MEMORANDUM

TO: Jean Fraser, Planner
FROM: David Senus, PE
DATE: June 10, 2015
RE: Lot 5 Industrial Way, Preliminary Level II Site Plan Application

Woodard & Curran has reviewed the Preliminary Level II Site Plan Application for the proposed Office building located at 81 Industrial Way in Portland, Maine. The project involves the construction of a 9,900 SF building, a 75 space parking lot, and associated site improvements.

DETENTION BASIN WITH UNDERDRAINED GRASS FILTER
NOT TO SCALE

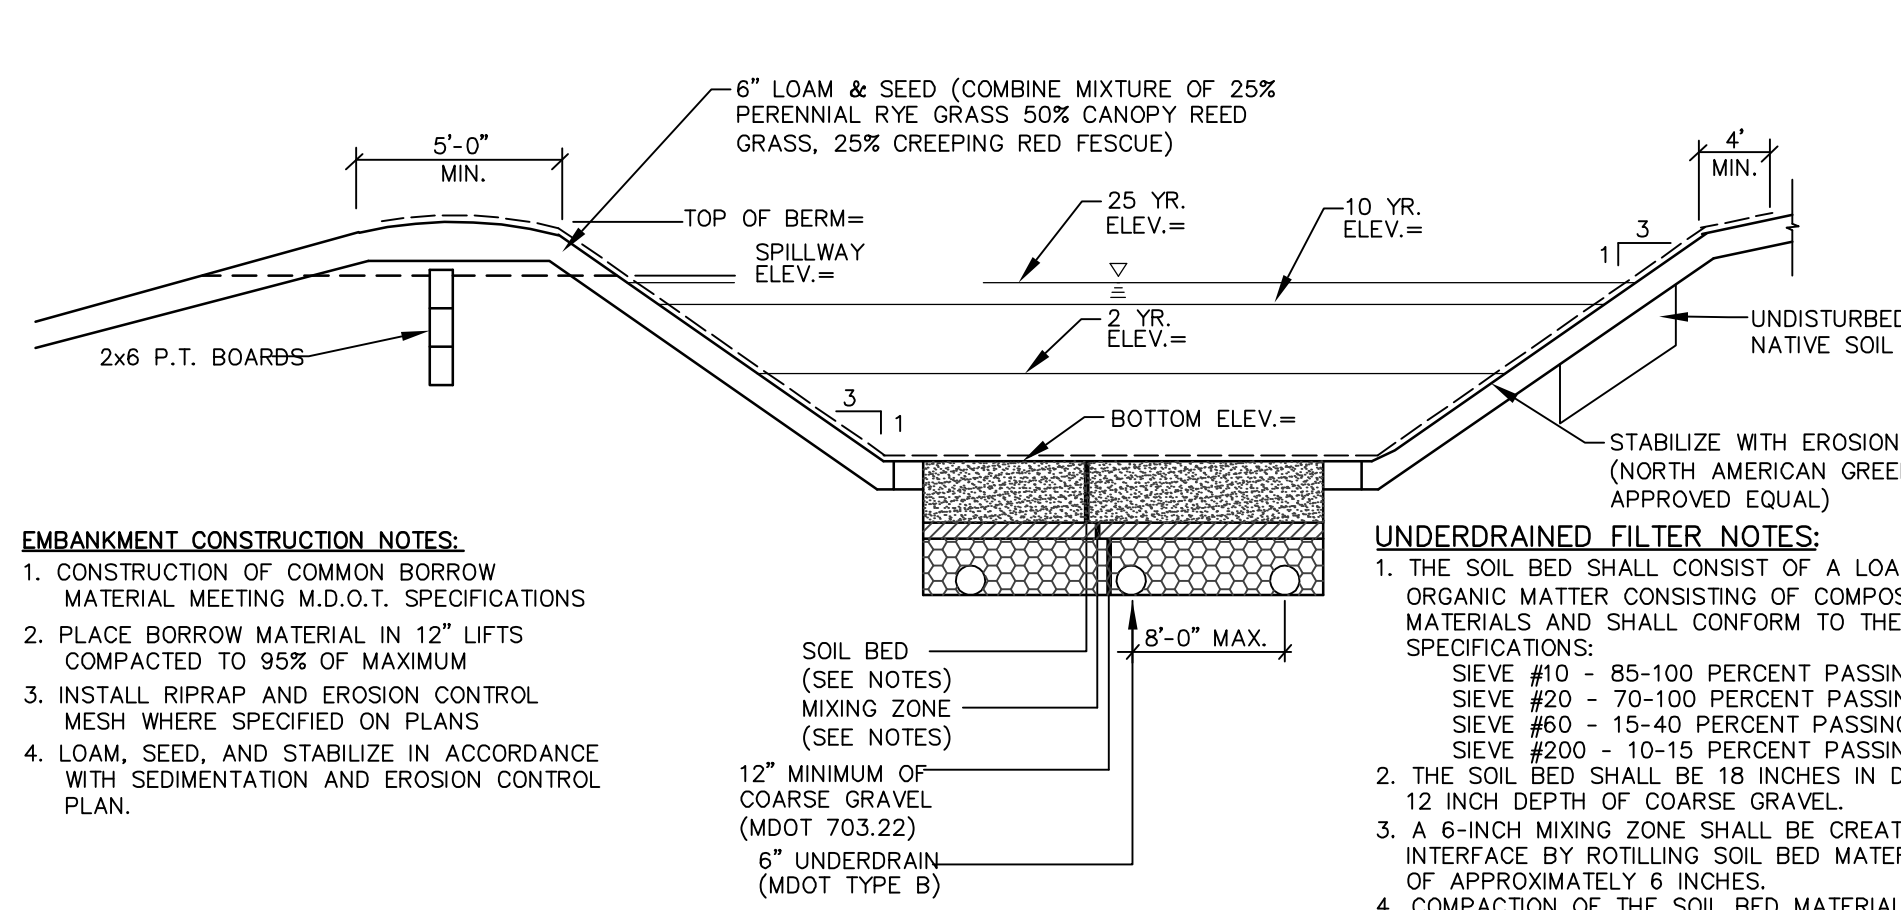
- 7) Riprap inlet and outlet protection should be specified on the plans for the proposed outlet from the soil filter basin and for the two driveway culverts.
- 8) The pipe material should be specified for the proposed driveway culverts located in the City ROW; refer to allowable pipe materials listed in the Technical Manual, Section 2.5.2. Culvert pipe invert elevations should be identified for the culvert proposed below the sidewalk.
- 9) Proposed elevations should be specified for the Underdrained Soil Filter.
- 10) The following details should be provided in accordance with the City of Portland Technical Manual for work within the Right-of-Way:
 - a) Curbing/tipdowns;
 - b) Bituminous Sidewalk; and
 - c) Trench Section.
- 11) The Detention Basin detail specifies six-inch underdrain, whereas the plan specifies four-inch; the Applicant should clarify.
